Transportation Noise Assessment Brief Comments Response
3285 Borrisokane Road (Block 19)
GWE File No.: 24-141 – Comments Response Letter

This letter outlines how we have addressed the comments from the City of Ottawa related to the transportation noise assessment brief of the proposed stacked townhouse development to be located on Block 19 of the Barrhaven Conservancy Subdivision (Phase 2,3), forming part of 3285 Borrisokane Road, Ottawa, ON.

OVERALL SITE PLAN

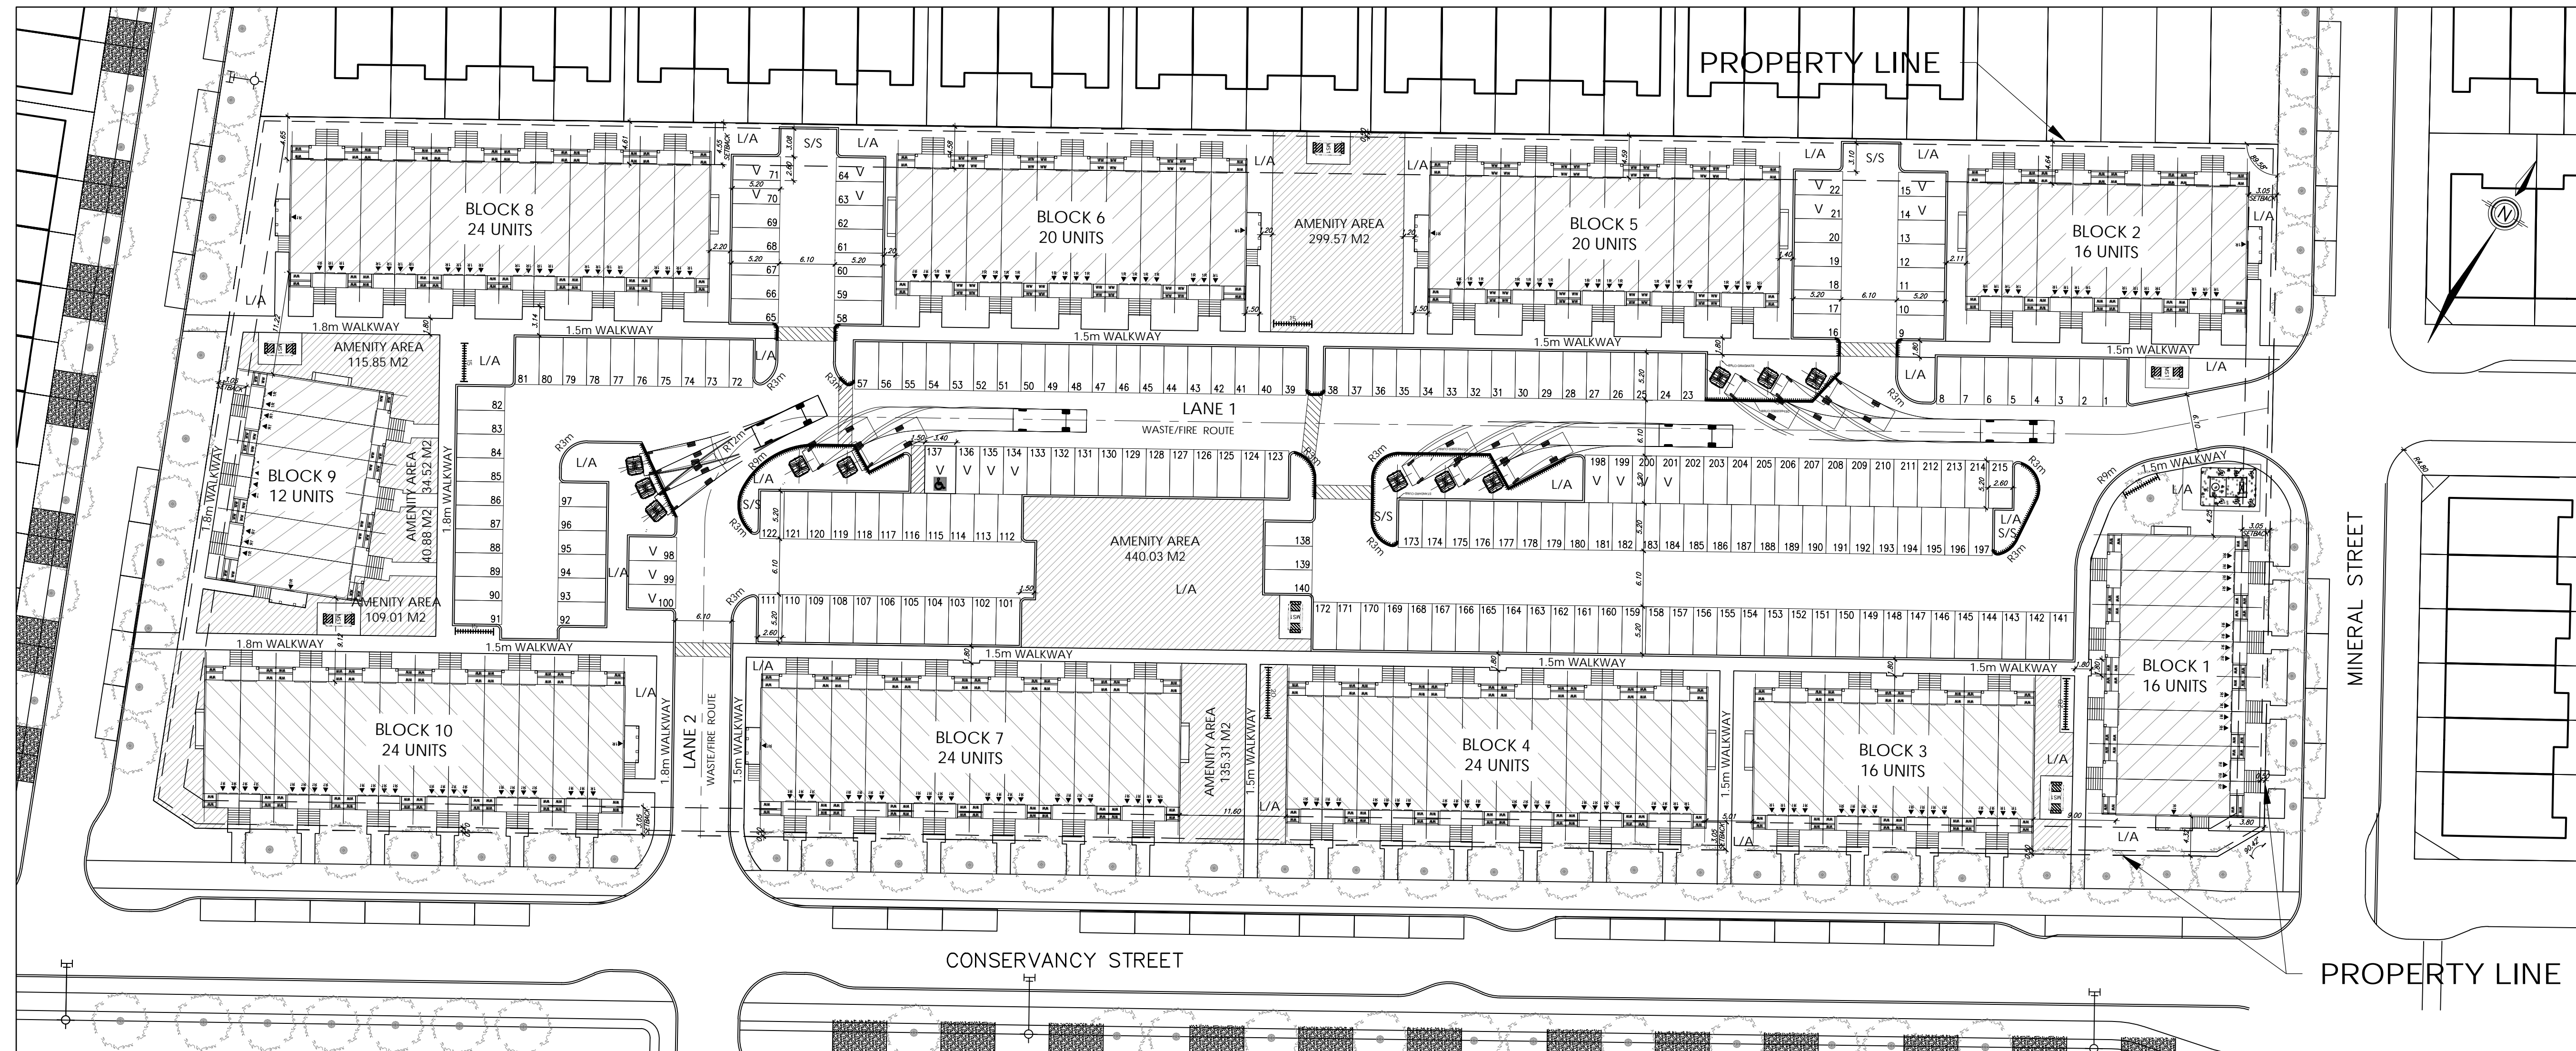
Comment 1: *The report states that there are no outdoor living areas (OLAs) associated with the development. Correct this sentence as the amenity areas shown on the site plan qualify as OLAs as per the City's Environmental Control Guidelines. Assess the predicted noise levels at these OLAs.*

GWE: Outdoor Living Areas (OLA) are spaces designed for the quiet private enjoyment of the outdoors. Accordingly, for standard single and townhouses, rear yards may require protection in the form of noise barriers from transportation and stationary noise generators. In such cases, the private yards are enclosed by noise fencing.

Balconies of less than 4 m in depth and common landscaped areas are not considered as OLA that require protection from noise sources. Enclosing common amenity areas with fencing would have the reverse effect of making these spaces inclusive and open to the community.

Our review and experience with other similar developments is that common amenity areas are not subject to OLA protection requirements.

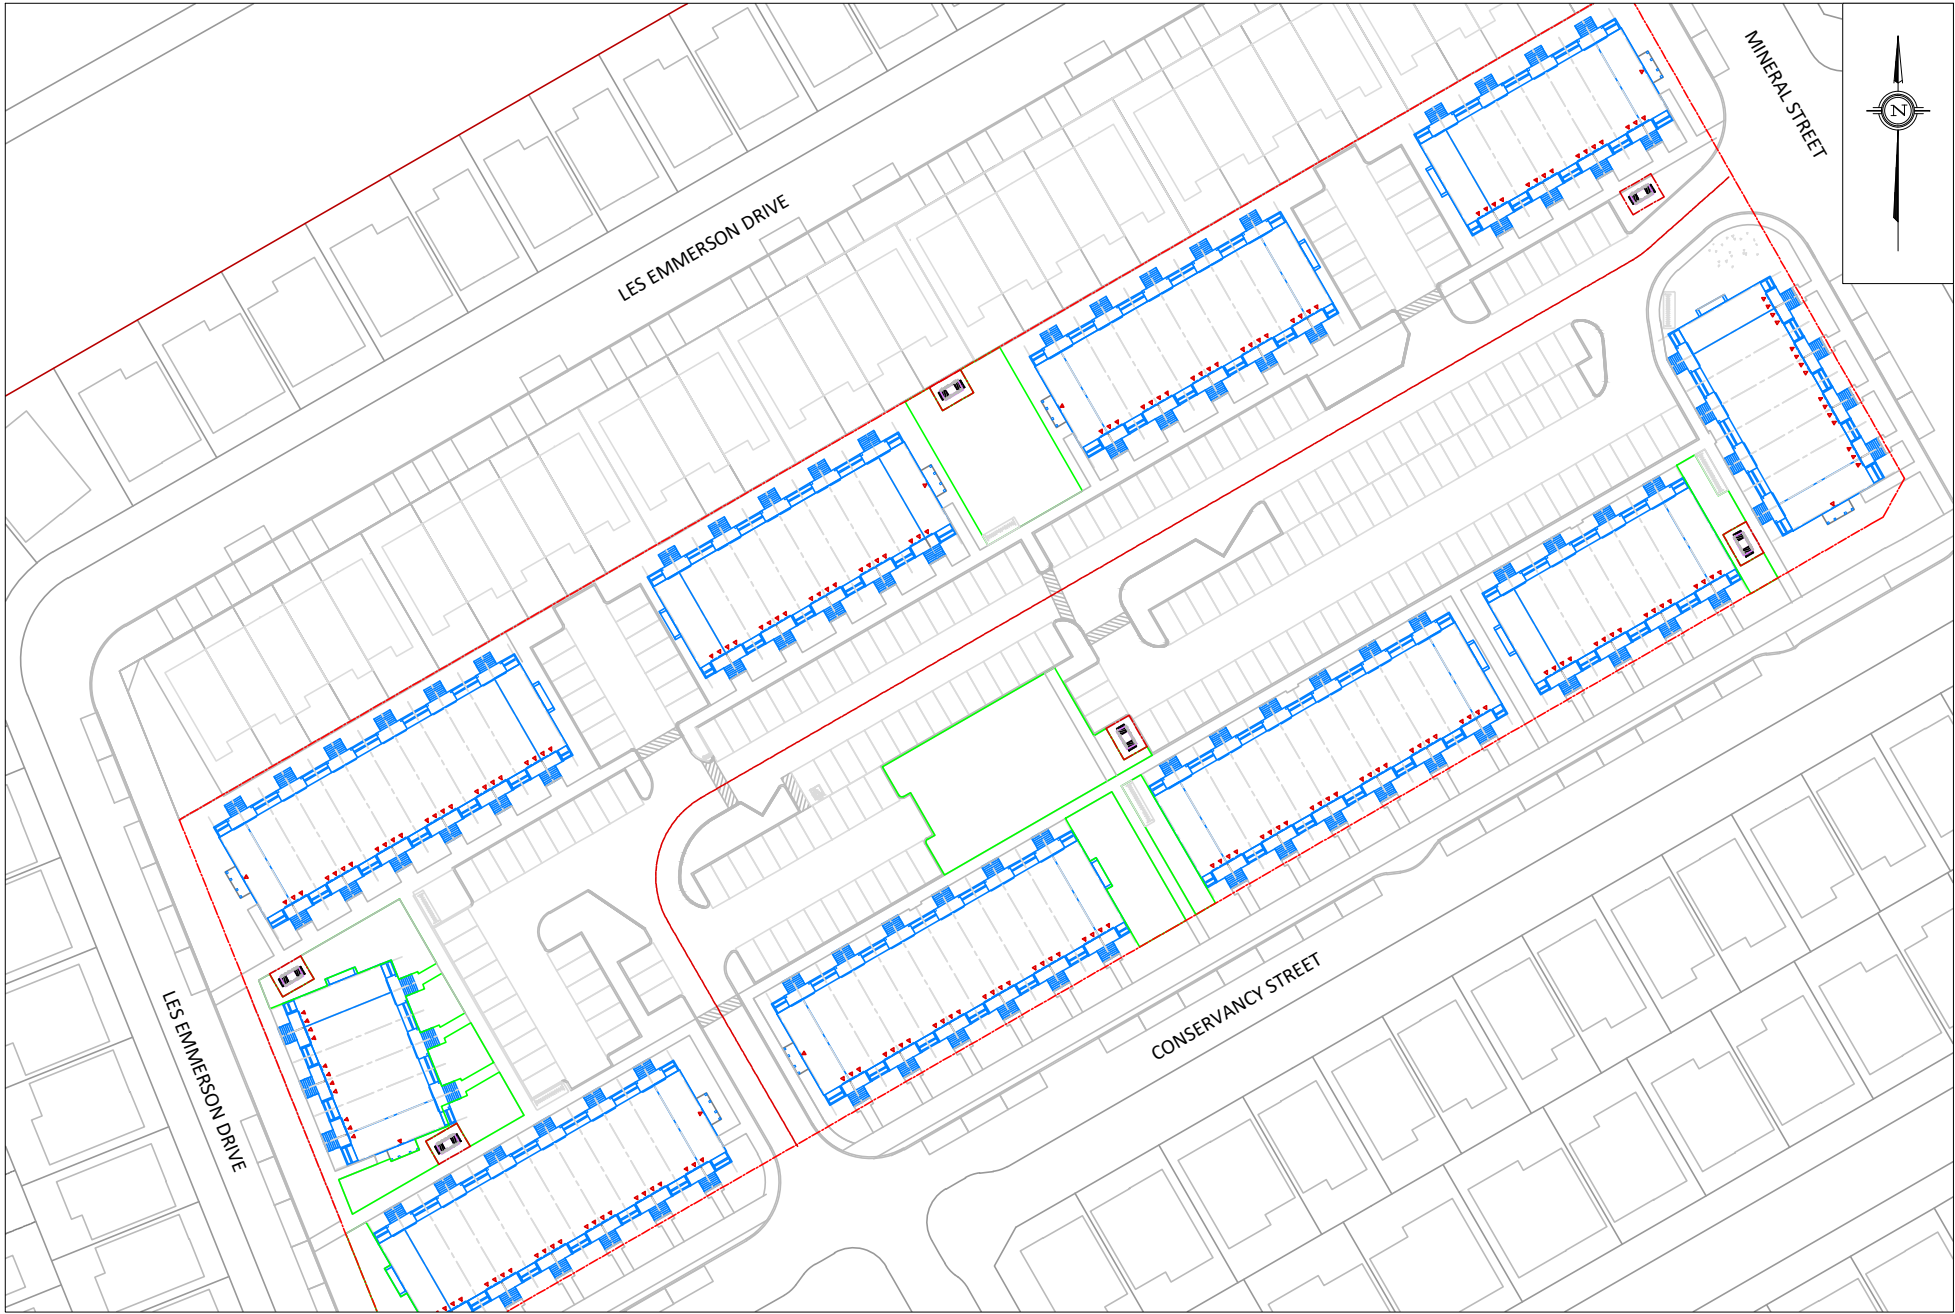
Comment 2: *Provide a list of all lots, blocks, unit, locations requiring noise control measures named and referenced in the study. Specific recommendation for each lot, block, unit, etc., documented in clear concise summary form for implementation purposes is required. Graphical representation (Figure 2) is not sufficient.*

GWE: The table containing mitigation measures and ventilation requirements can be seen below.

Warning Clause	Ventilation Requirement	Applicable Blocks/Dwellings
Type C	Forced Air Heating with Provisions	Blocks 1, 3, 4, 7, and 10
N/A	N/A	Blocks 2, 5, 6, 8, and 9
